Rezoning Transportation Analysis

Petition Number: 2020-111

General Location Identifier: 14117104.

Date	Description
09-10-20	First Review (KP)
10-19-2020	Second Review (KP)
11-30-2020	Third Review (KP)

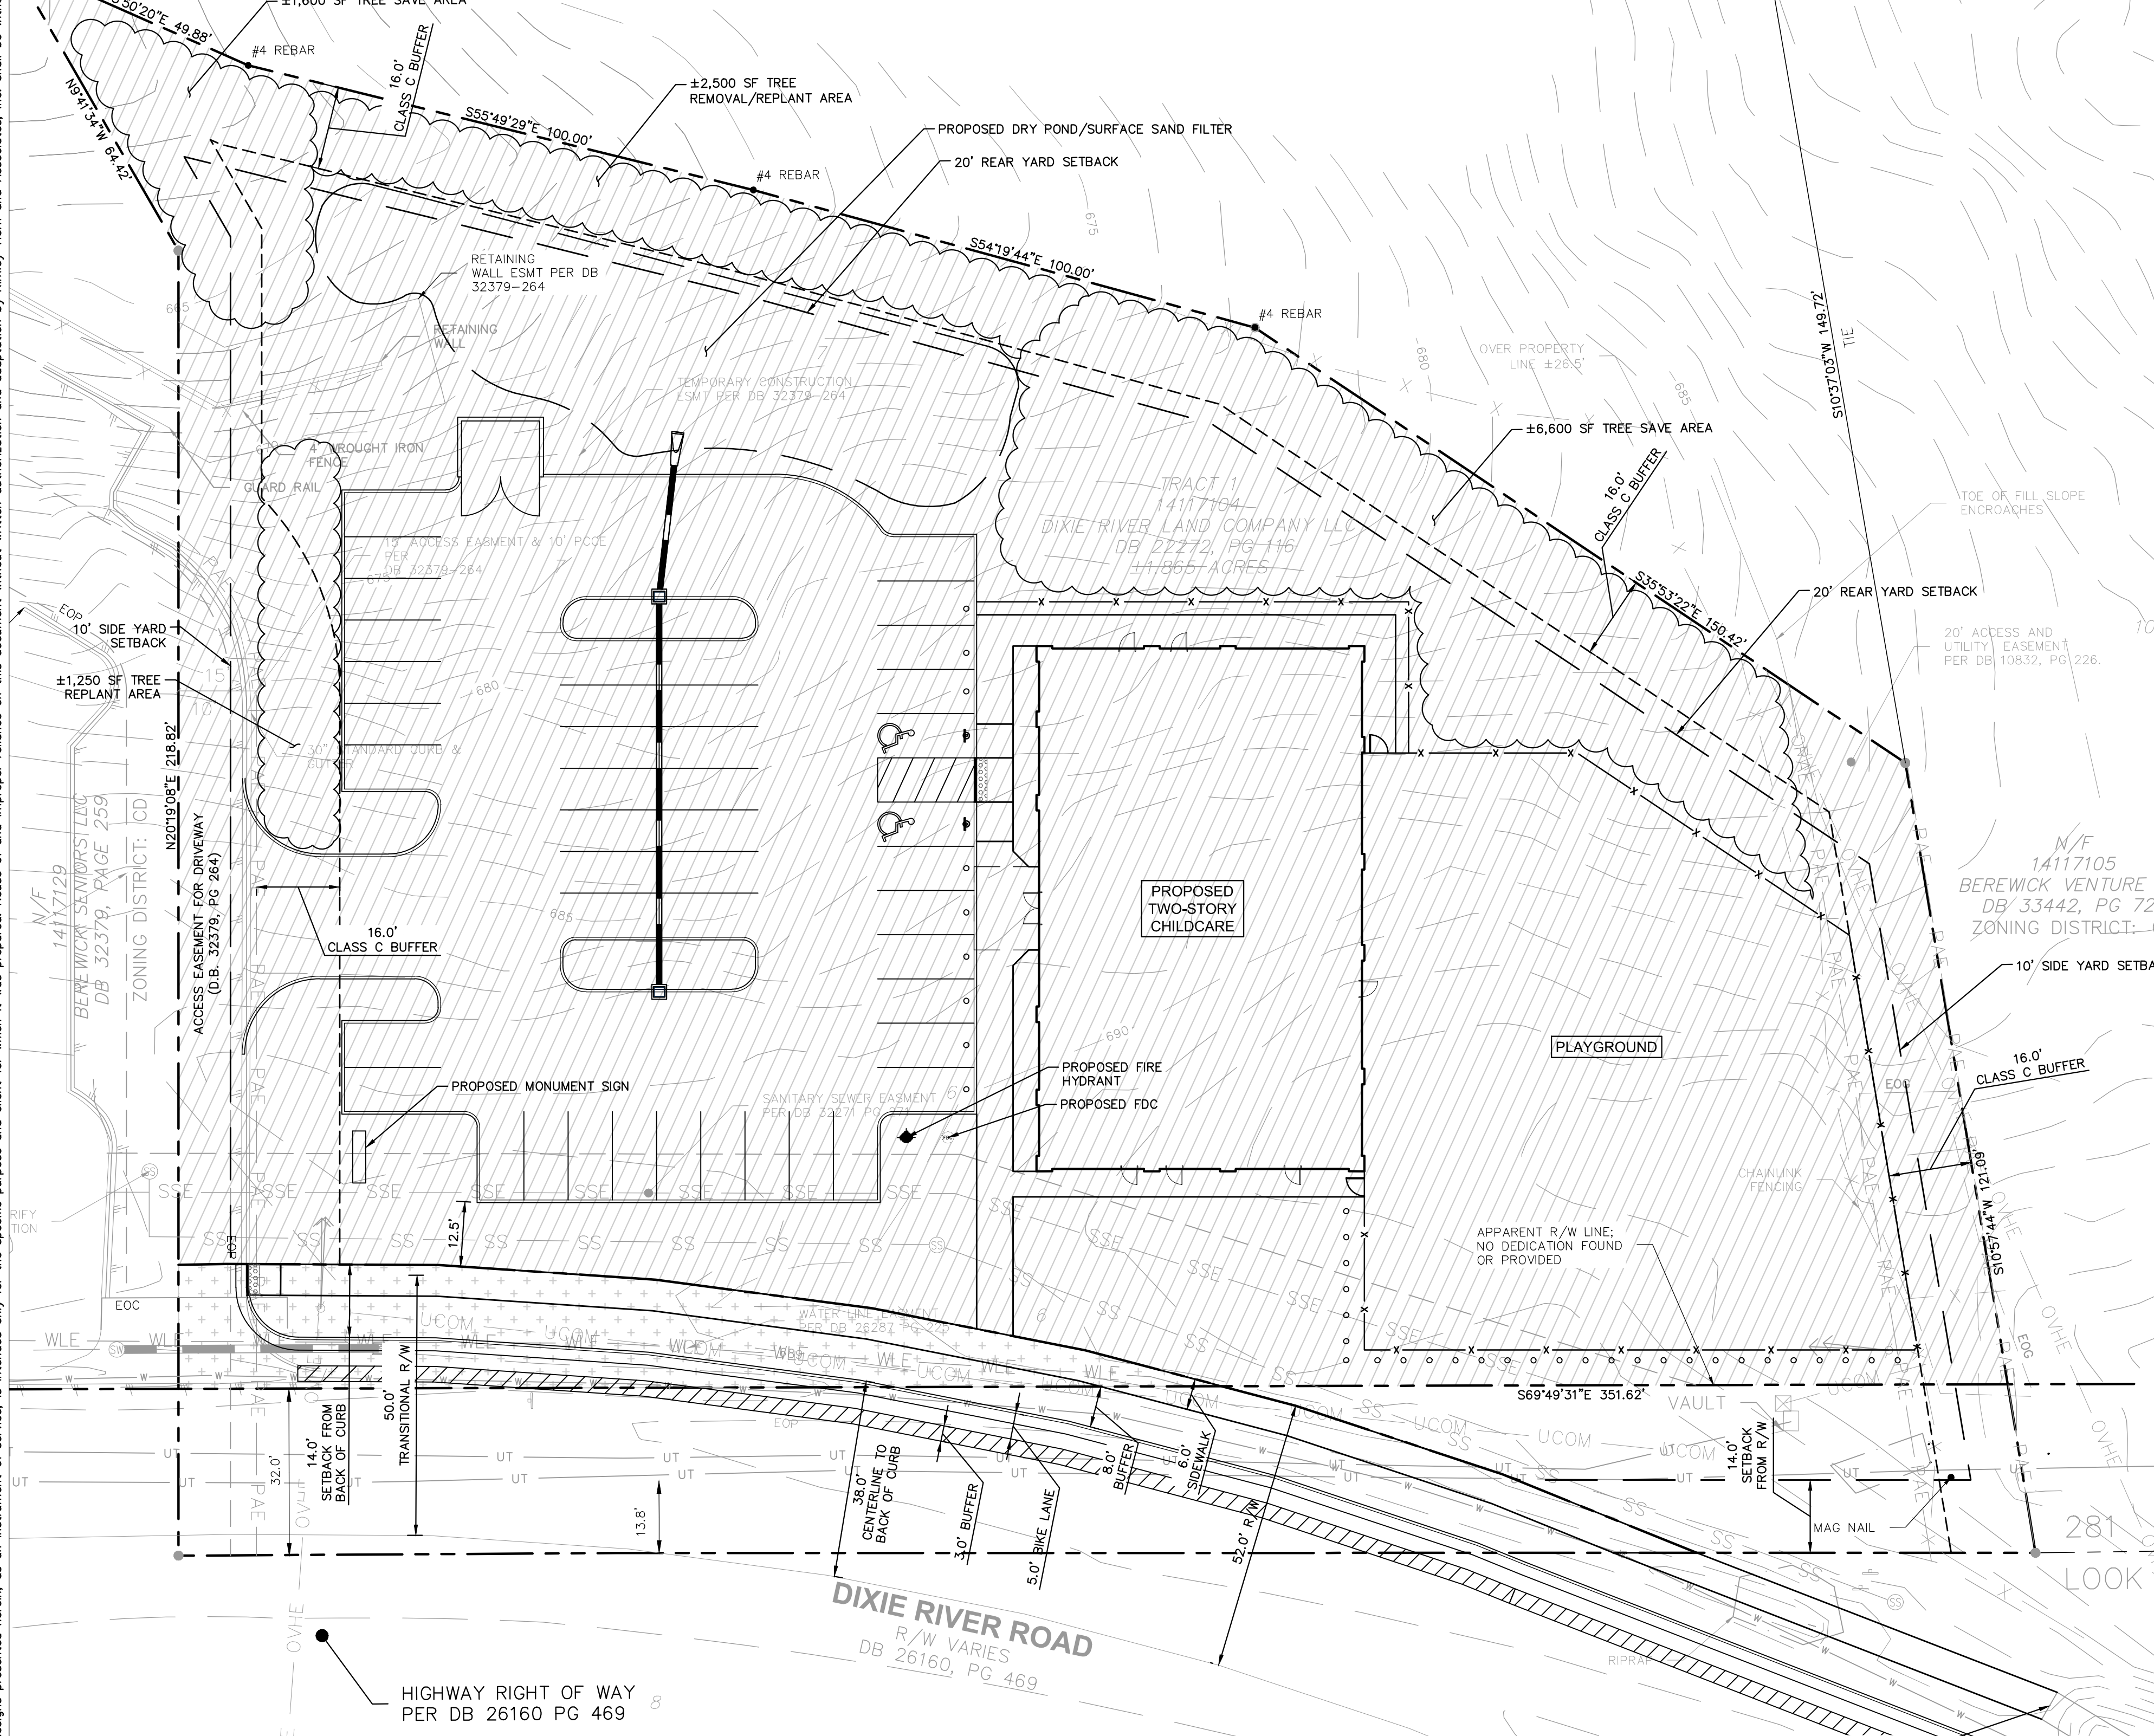
- a. **Dixie River Road:** Update location of curb and gutter 38 feet from center line to back of curb.

Label and dimension curb and gutter from the center line for each road.

- 3. Commit to dedicate 52 feet of right of way from the Dixie River Road centerline, labeled and dimensioned from the road centerline, on the site plan and conditional note(s).

- 4. Commit to construct an 8-foot planting strip, and 6-foot sidewalk on Dixie River Road and connect to the sidewalk constructed as a part of the Berewick Senior Apartments development, as required by City Ordinance. This should be shown on the site plan, labeled and dimensioned from the back of curb and gutter, as well as noted in the conditional notes.

- 5. The petitioner should revise the site plan and conditional note(s) commit to construction of a 5-foot bike lane with a 3-foot buffer along Dixie River Road, labeled and dimensioned from the road centerline.

- 6. Commit to the removal of the existing obsolete driveway(s) in and near the southeast corner of the property. **Update to Comment from 10-12-2020 Site Plan:** Please include in the conditional notes.
